Further WSCC Highways comments

In response to the CEMP comments I can now respond as follows:

I trust this closes out the comments and will enable you to discharge Outline condition 16.

Traffic Route Plan

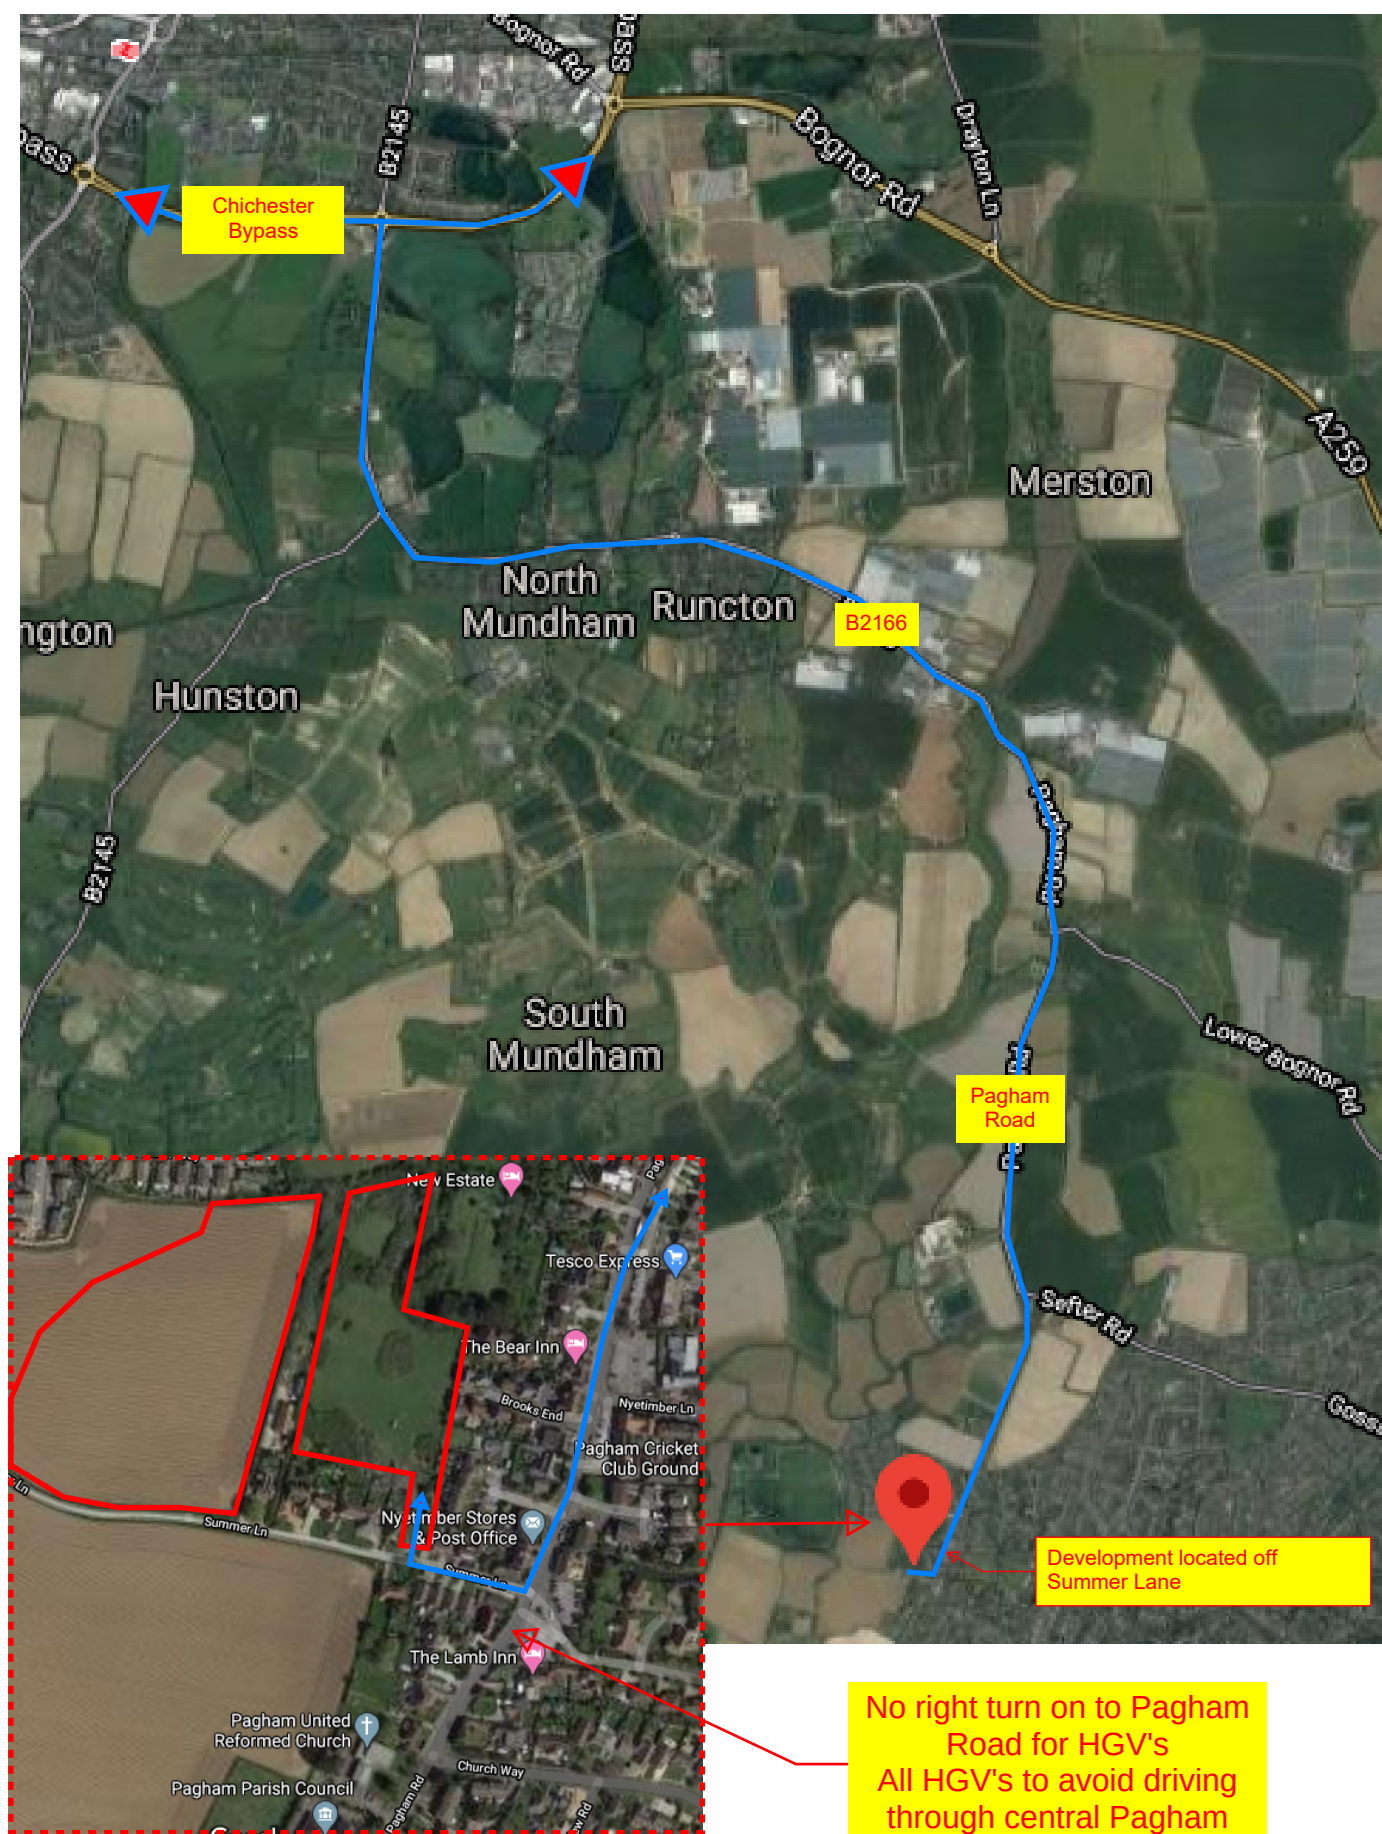
The routing plan for construction traffic follows the WSCC recommendation.

3. Vehicle routing: The CEMP includes a traffic routing plan which has been updated to show the traffic routing from the development to Chichester Bypass. A clear note has been added to the revised plan to state that HGV's must not turn right on to Pagham Road and they should avoid central Pagham.
